From: TownPlanning LNW [TownPlanningLNW@networkrail.co.uk]
Sent: 14 March 2012 14:43
To: planning
Subject: Ribble Valley ref 3-2012-0185 Victoria Street Garage Clitheroe demolition and erection of 3 storey apartment

Victoria Street Garage Victoria Street Clitheroe Lancashire
Application for the renewal of planning permission 3/2008/0766P for the proposed demolition of commercial building and erection of a 3-storey building forming nine two-bedroom apartments with ancillary lift and staircase enclosure.
E 373761 / N 441162

S.J. Bialecki Limited Building Surveyors	Drawing no 7004	Scale 1:100	Existing Layouts And Elevations	Proposed Residential Development On Land Off Victoria Street Clitheroe
---	-----------------	-------------	------------------------------------	--

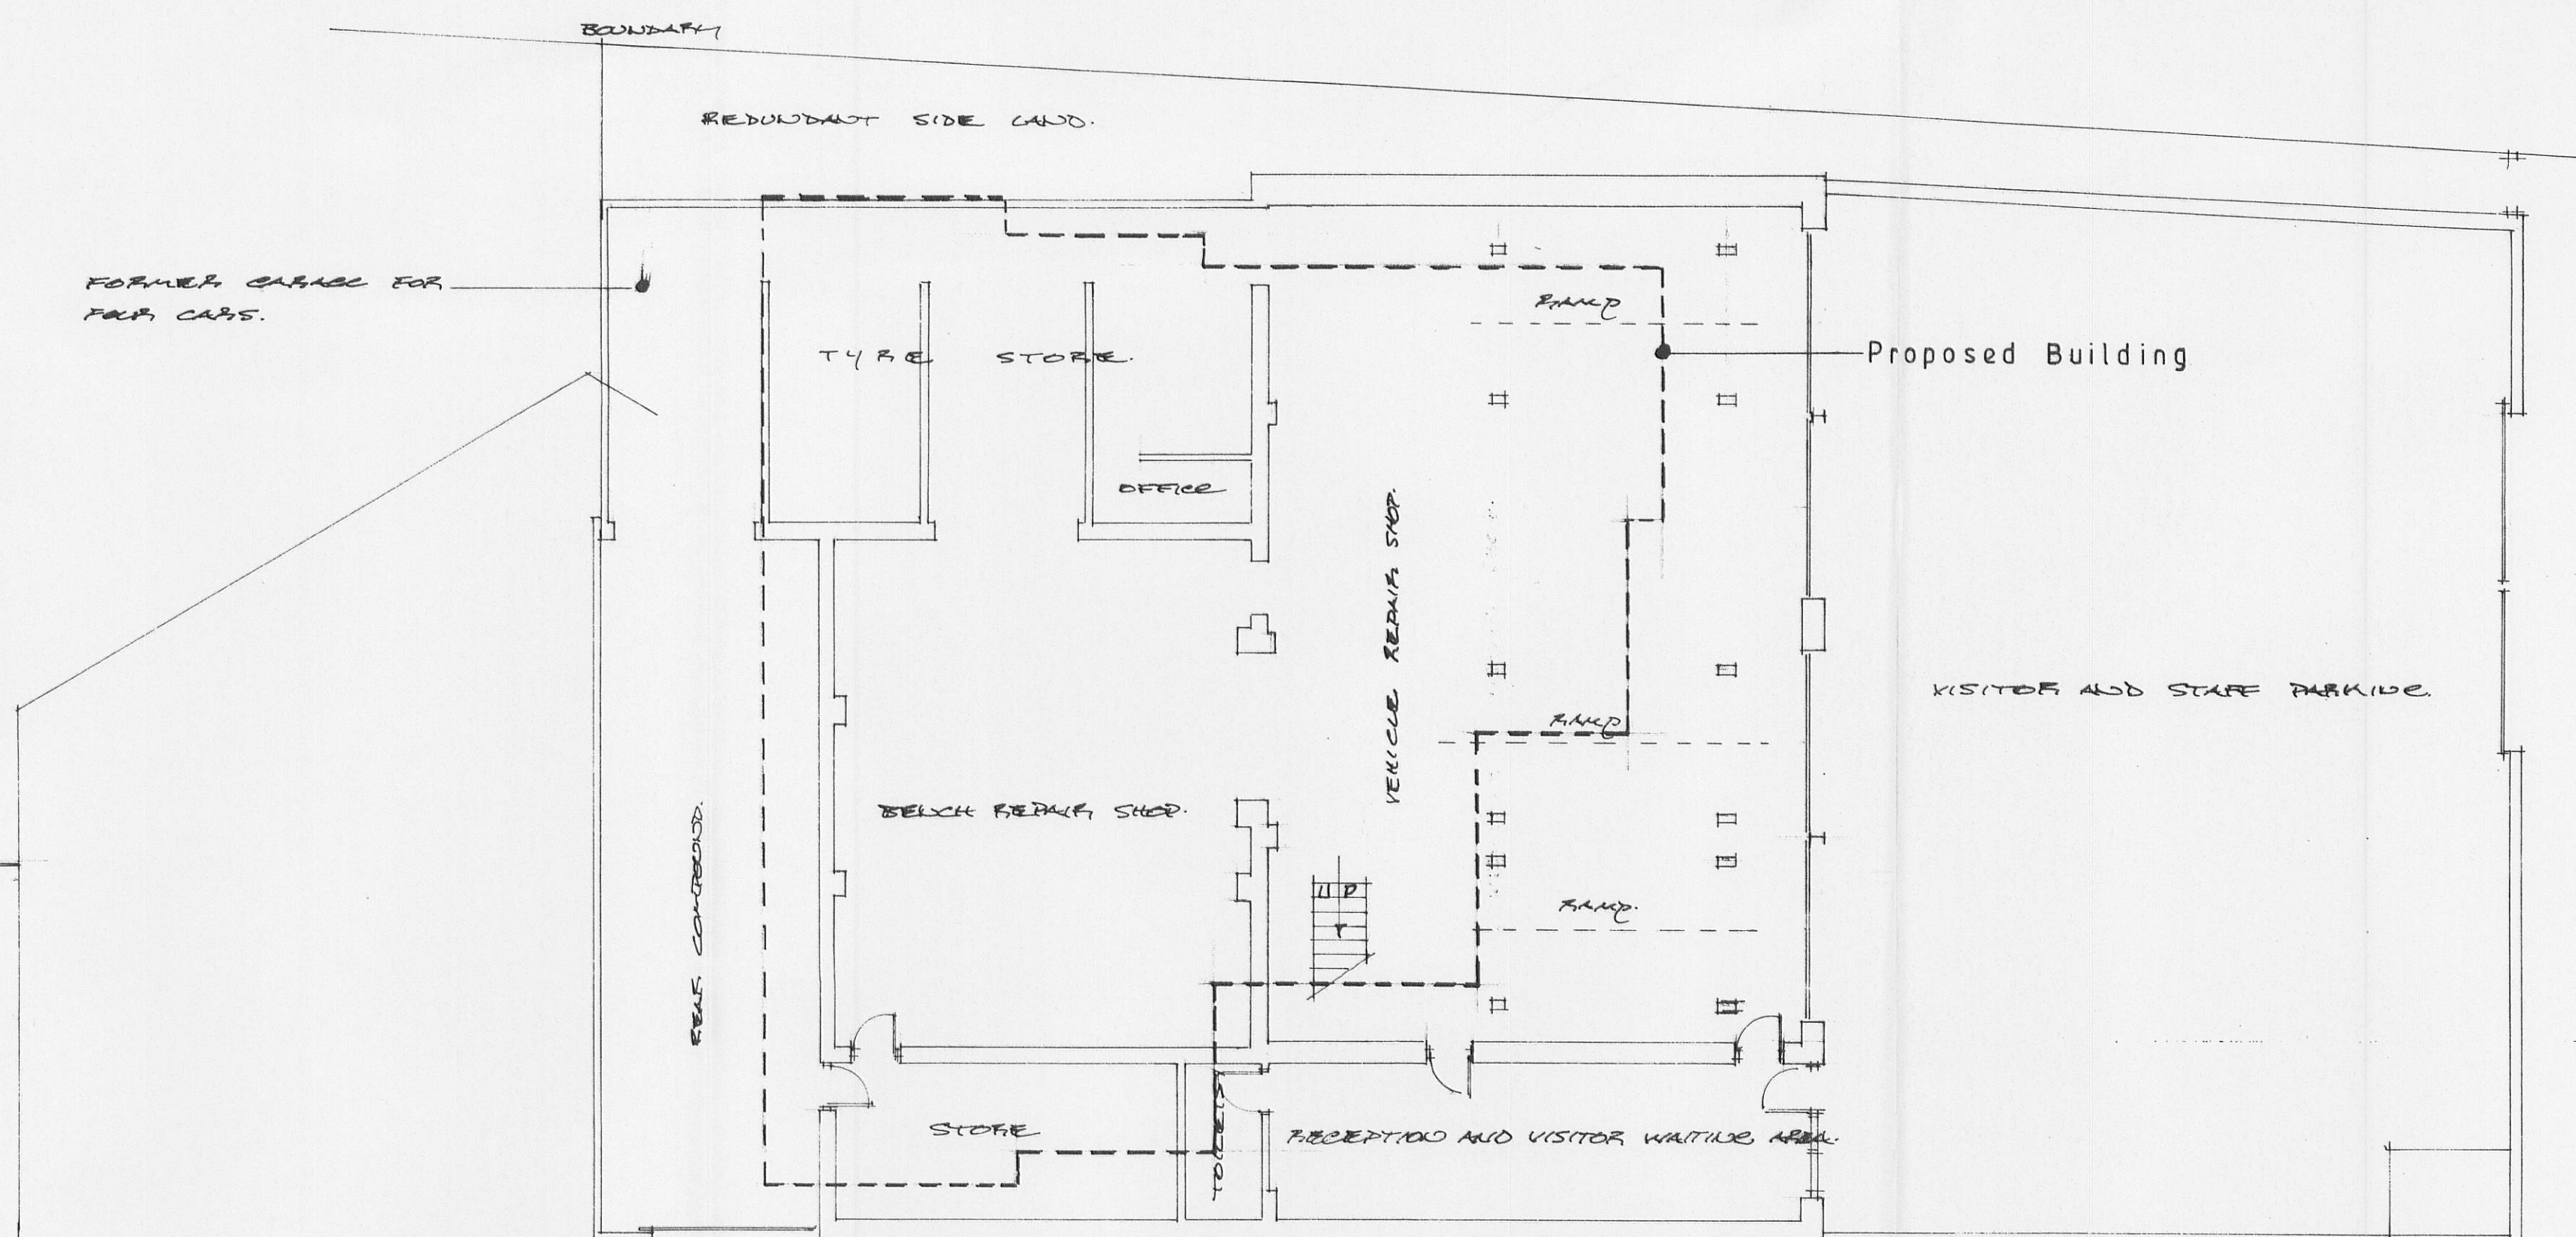
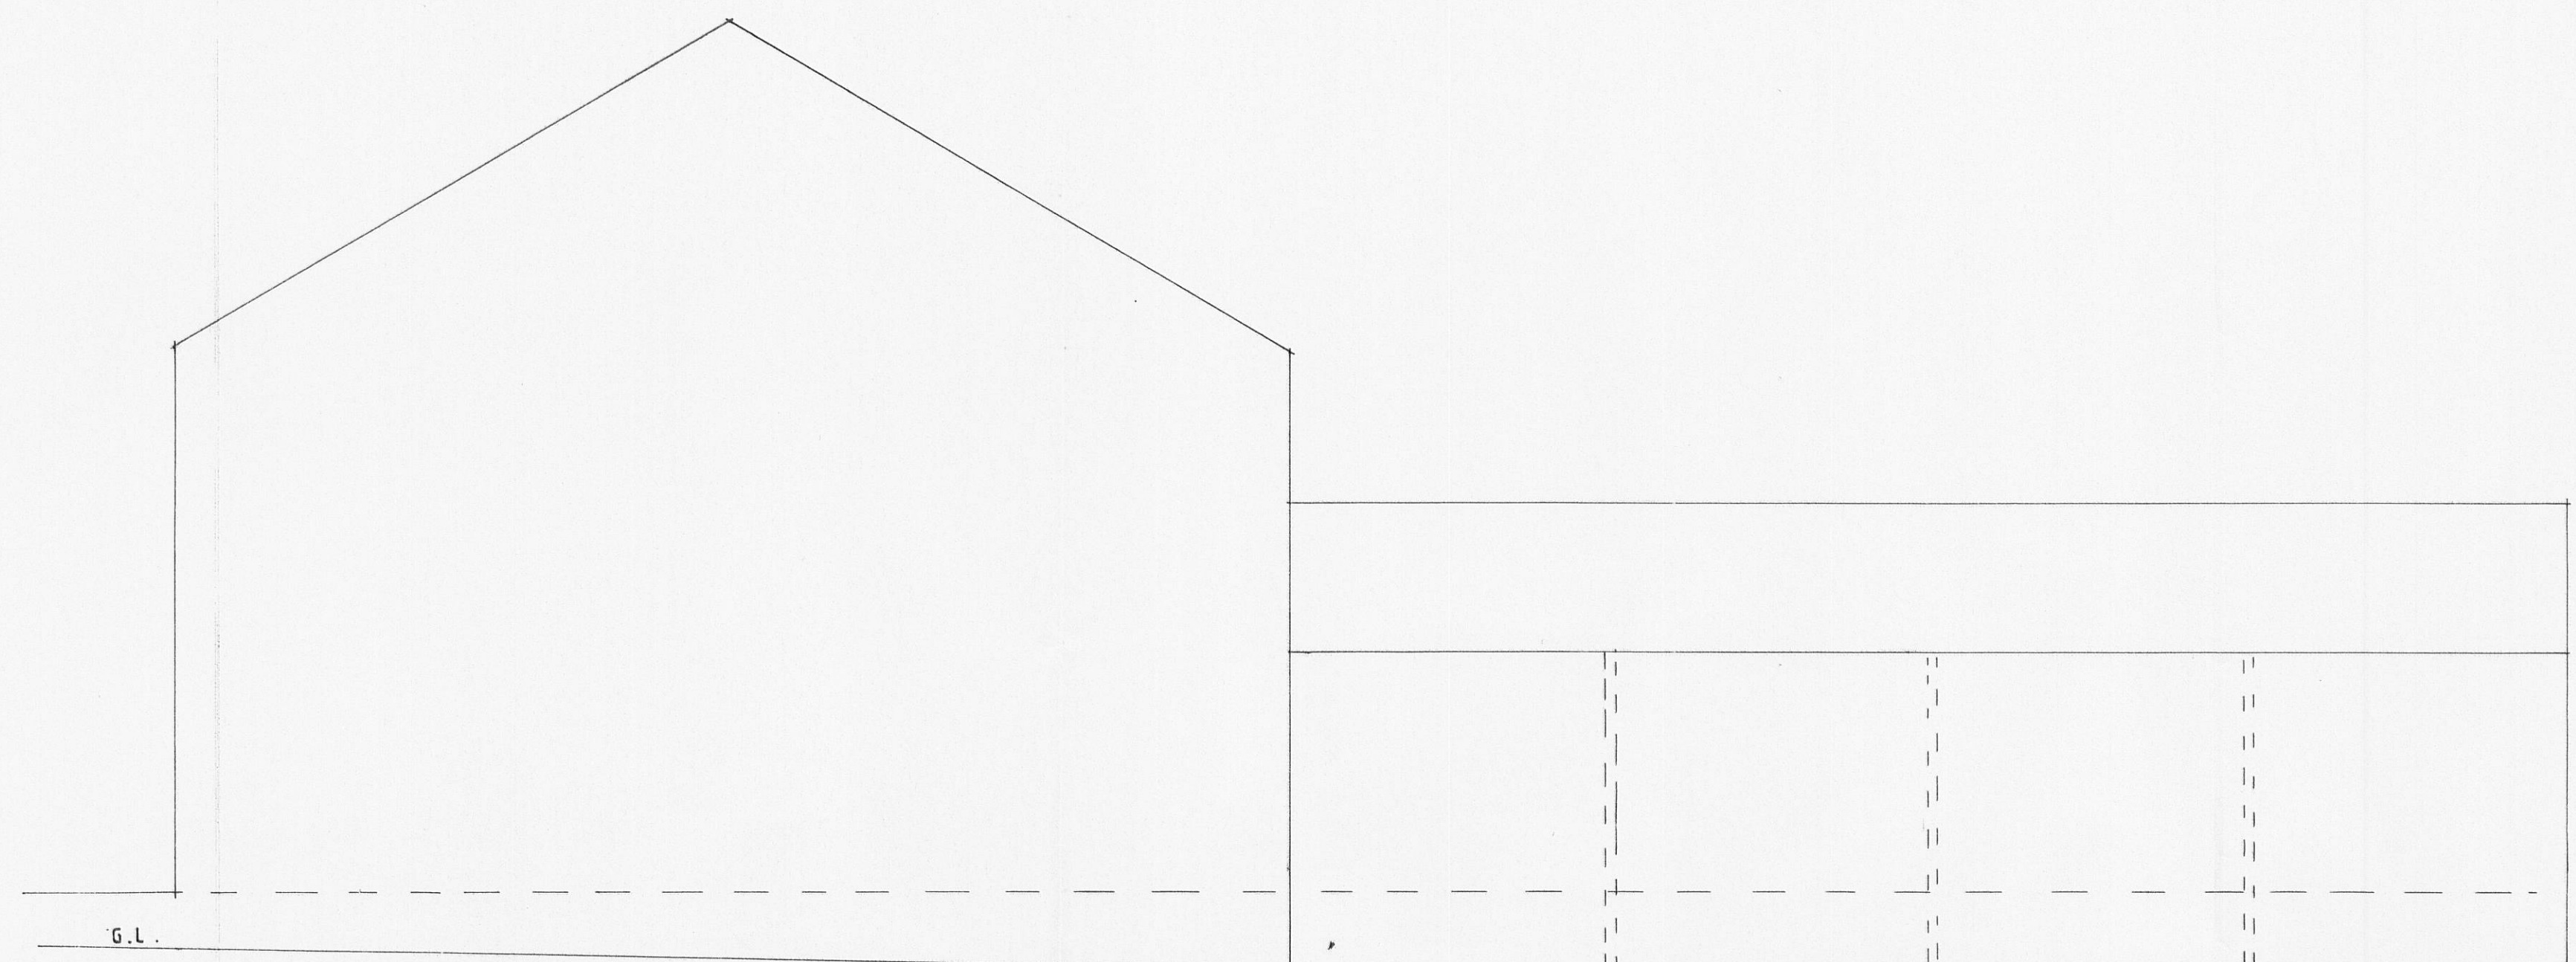
- (1) The design and access state mentions British Rail Track land, the operational railway land is in the ownership of Network Rail, Railtrack has not existed since 2002.
- (2) The proposal calls for the demolition of the existing building and perimeter walls. The applicant has not stated if the demolition of the perimeter walls also includes walls along the boundary with Network Rail. The demolition works must not endanger the safe operation of the railway, or the stability of the

adjoining Network Rail structures. The demolition of the existing building and walls near to the operational railway infrastructure must be carried out in accordance with an agreed method statement. Approval of the method statement must be obtained from Network Rail's Asset Protection Engineer before the development can commence. Email: AssetProtectionLNWNorth@networkrail.co.uk

| Drawing no 7005/a                                                                  |

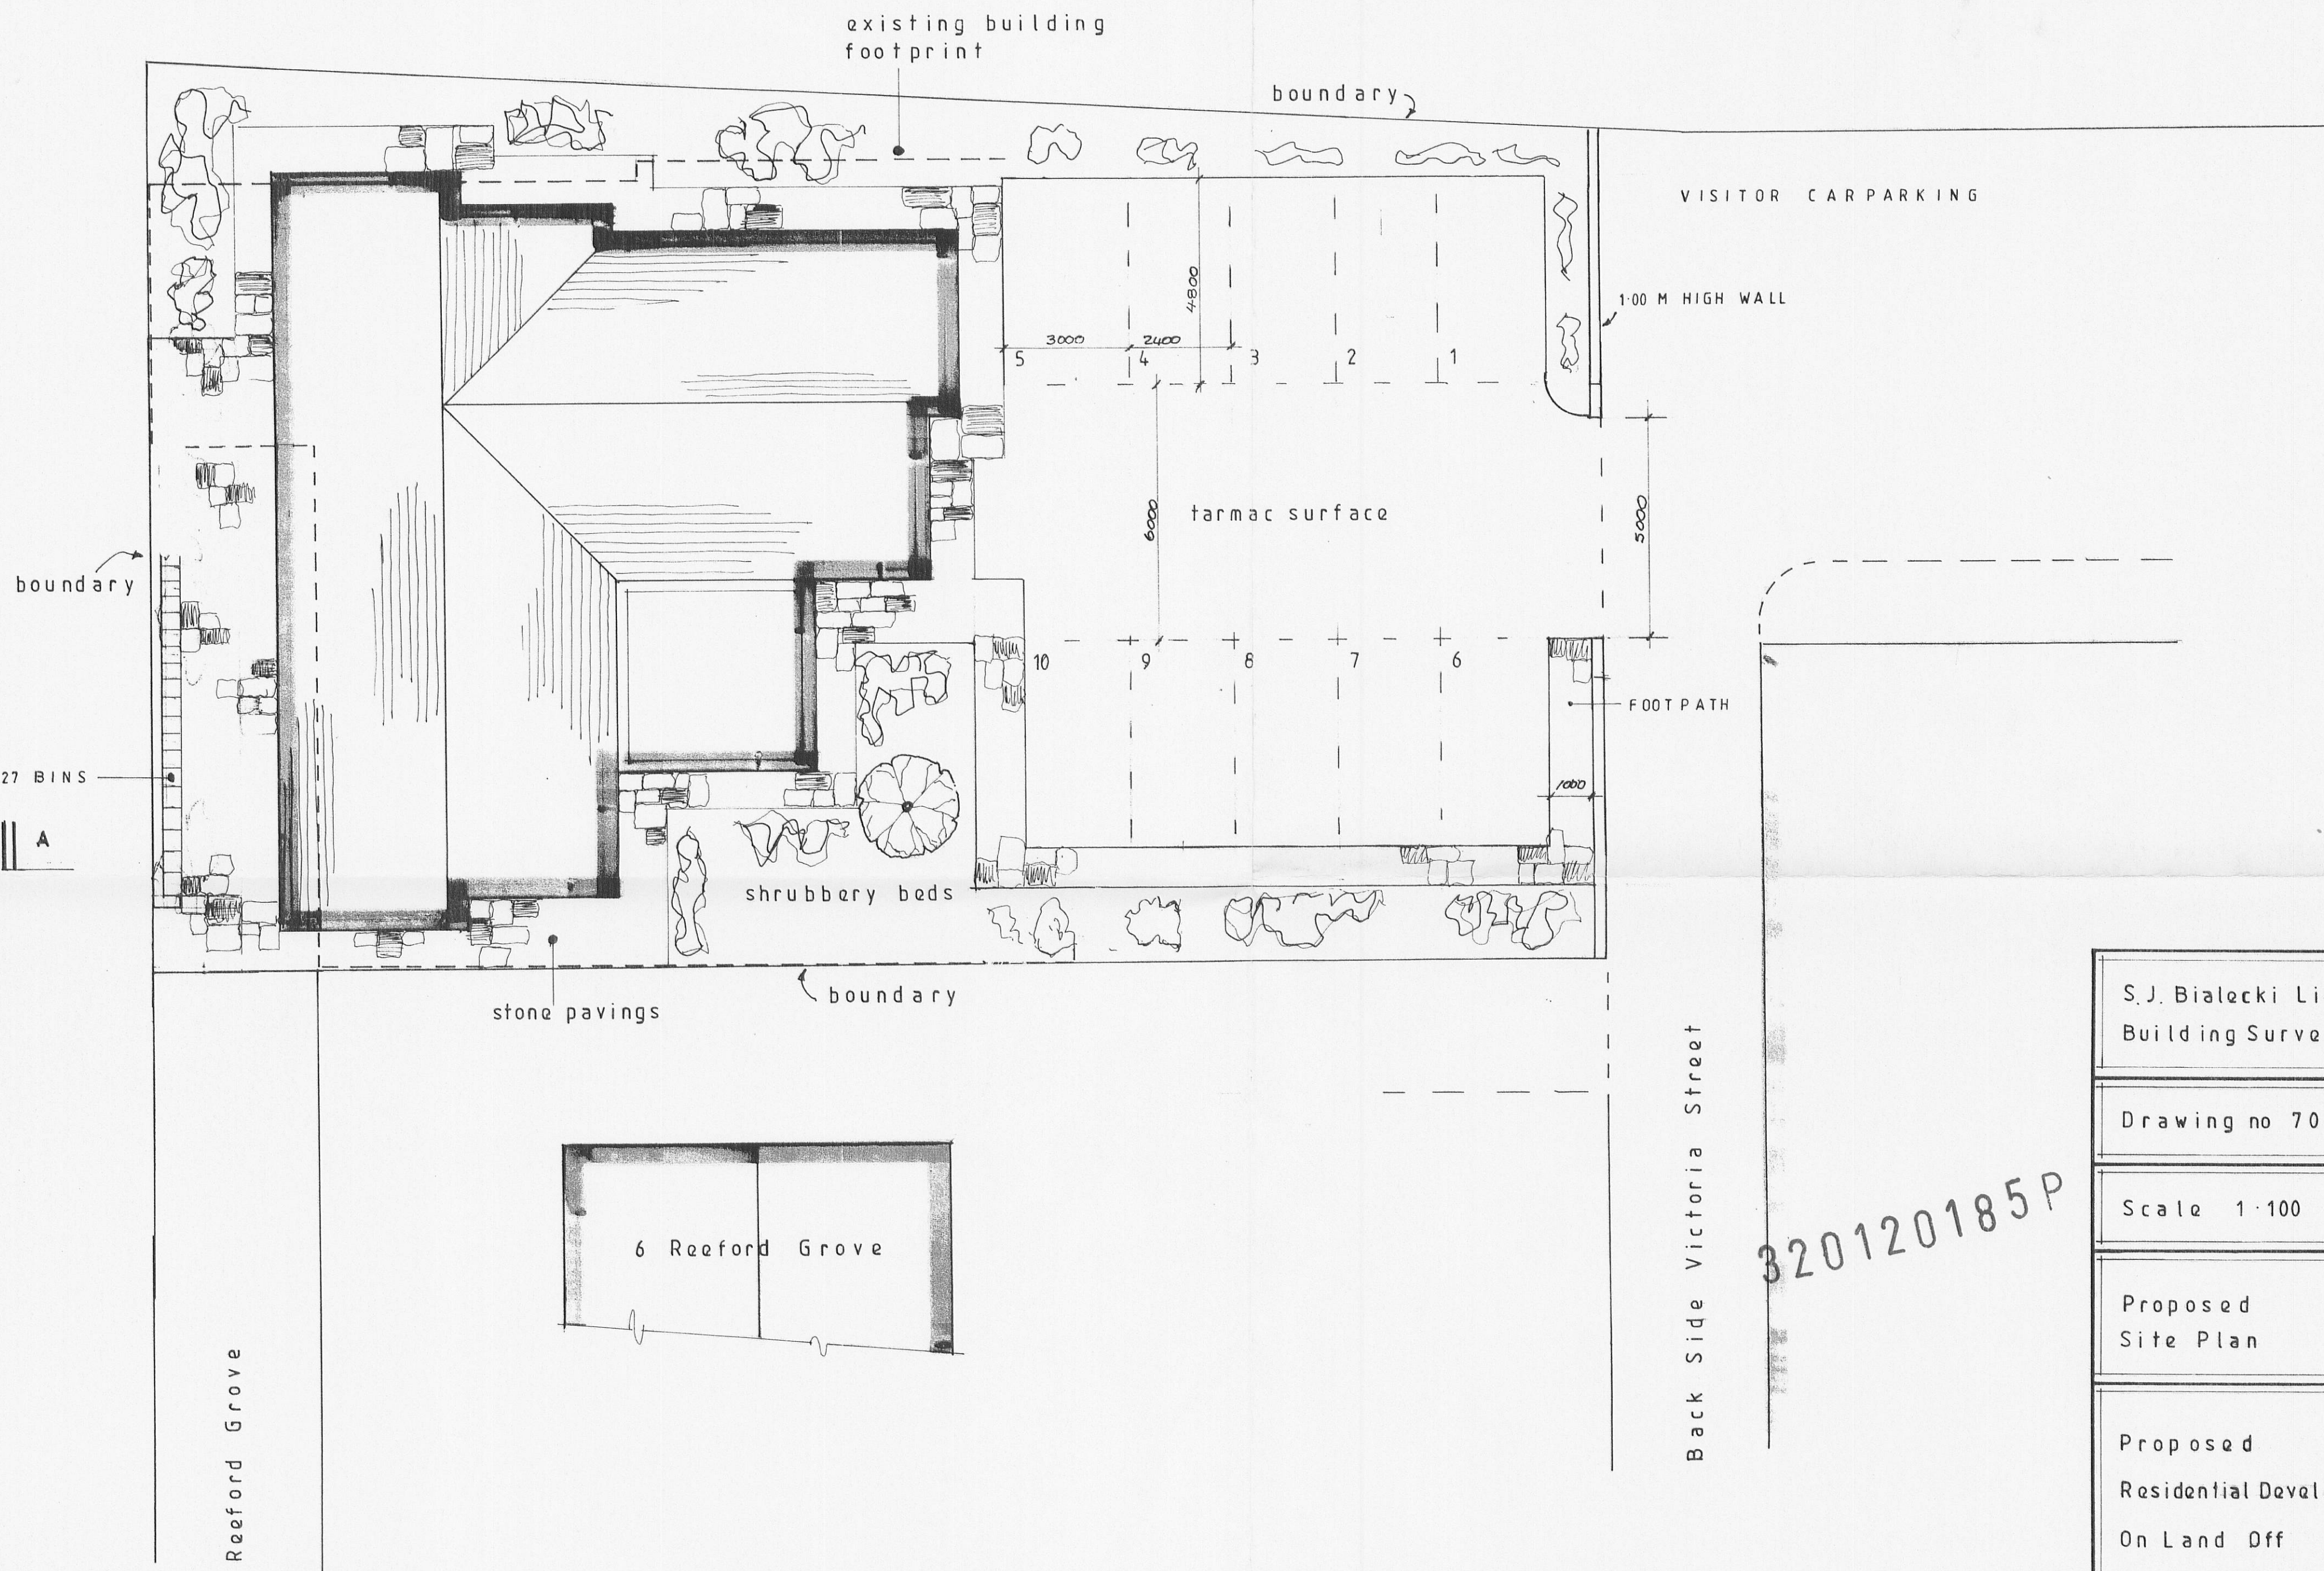
- (3) The applicant has proposed a 2.0m high hit and miss timber panel fence. Any fencing erected must not impact upon any existing Network Rail fencing or walls. Any Network Rail existing fencing or walls must not be damaged, removed or altered in any way (this includes any foundations), and the applicant's fencing must not prevent Network Rail from maintaining or renewing our boundary treatment. Ideally we would request that the applicant installs (at their own expense) a 1.8m high trespass proof steel palisade fence as any residential proposal imports a risk of trespass to the operational railway and as the applicant has chosen to develop the site, the applicant should mitigate any imported risks. We would remind the council that trespass is a criminal offence (s55 British Transport Commission Act 1949).

- (4) Storm/surface water must not be discharged onto Network Rail's property or into Network Rail's culverts or drains except by agreement with Network Rail. Suitable drainage or other works must be provided and maintained by the Developer to prevent surface water flows or run-off onto Network Rail's property. Proper provision must be made to accept and continue drainage discharging from Network Rail's property. Full details of the drainage are to be submitted for approval to the Network Rail Asset Protection Engineer. Suitable foul drainage must be provided separate from Network Rail's existing drainage. Soakaways, as a means of storm/surface water disposal must not be constructed near/within 10 metres of Network Rail's boundary or at any point which could adversely affect the stability of Network Rail's property.

- (11) Where trees/shrubs are to be planted adjacent to the railway boundary these shrubs should be positioned at a minimum distance greater than their predicted mature height from the boundary. Certain broad leaf deciduous species should not be planted adjacent to the railway boundary as the species will contribute to leaf fall which will have a detrimental effect on the safety and operation of the railway. Any hedge
